**Site 53 – Project Delivery Agreement – State Significant Development
Application – Land Owners Consent**

I refer to State Significant Development Application for a mixed use development at Site 53, 2 Figtree Drive, Sydney Olympic Park.

SOPA's Planning Unit has reviewed the application and recommends the following items be considered:

AUSTRALIA AVENUE FRONTAGE

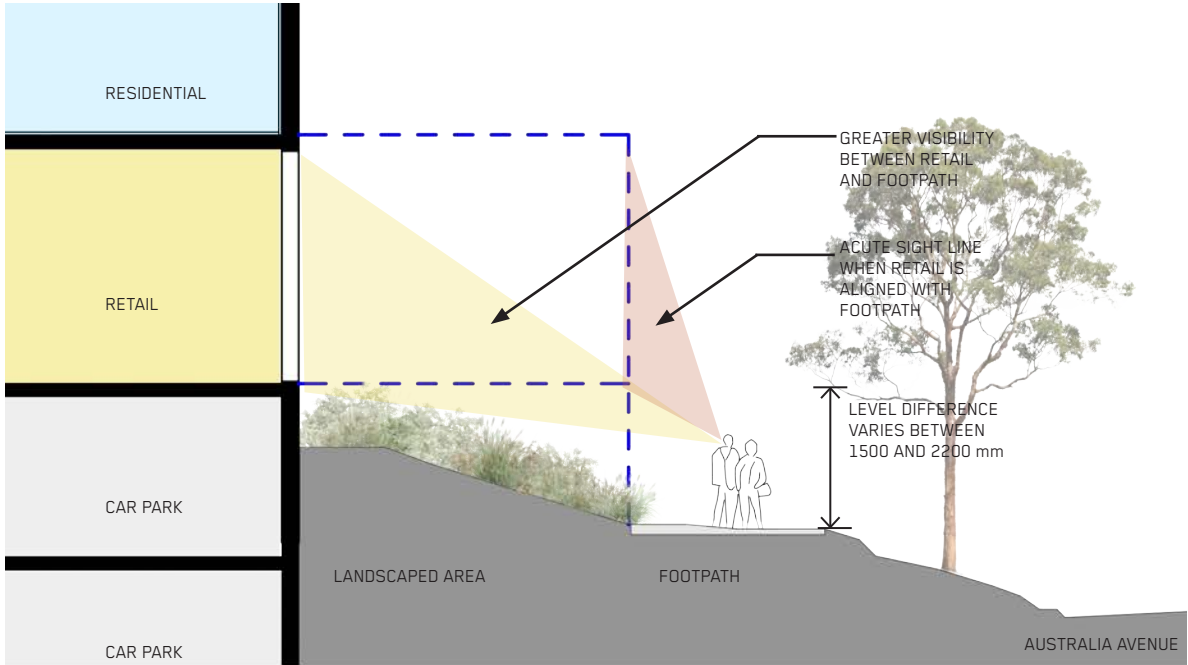
- Extending the retail/commercial building to the Master Plan boundary on Australia Ave to provide a better presence.
- Improving the public access around the fig tree's (T2 & T3) in the NE corner. Consideration should be given to:
